## CHERWELL DISTRICT COUNCIL

### TOWN AND COUNTRY PLANNING ACT 1990 CONSULTATION - PLANNING APPLICATION

**Application No:** 19/02948/F  
**Applicant's Name:** Rectory Homes Ltd

**Proposal:** Erection of 10 dwellings  
**Location:**  
**Parish:** Steeple Aston

Plan showing proposed pedestrian infrastructure along South Side

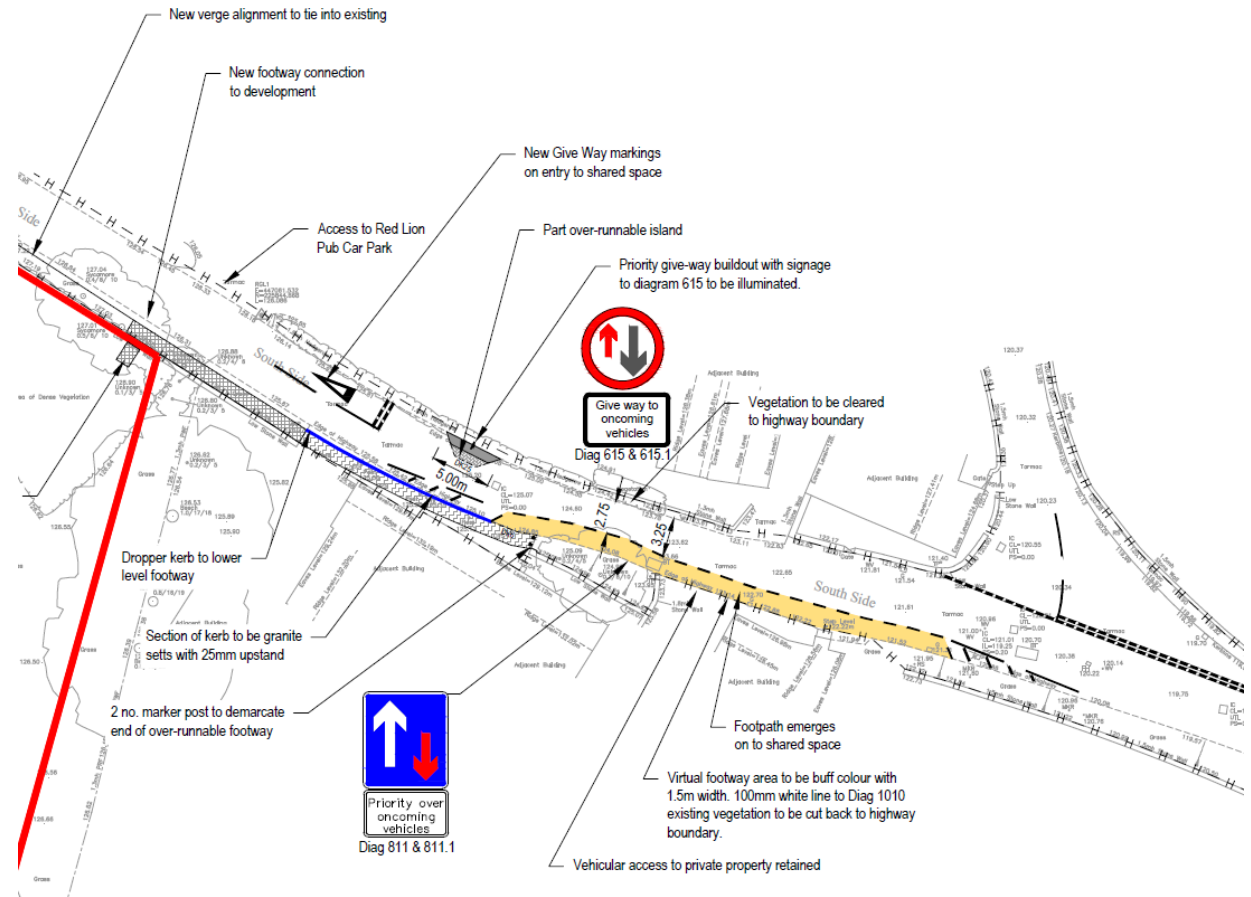
- Road markings and signage: can we have some assurance that the new road markings and signage will be well maintained so that the new road layout preserves a high degree of safety?

- The narrowness of the road where there is to be a 'build out': we have been approached by a local farmer who has pointed out that he needs to be able to get wide farm vehicles into and through the village. Can he be assured that this will be possible?

We are reassured that the Safety Audit carried out by the applicants has resulted in improved proposals, and that it will be the responsibility of the Highways Authority to maintain markings, etc.

The revised arrangements demonstrate that large farm vehicles will be able to negotiate the narrowest section.
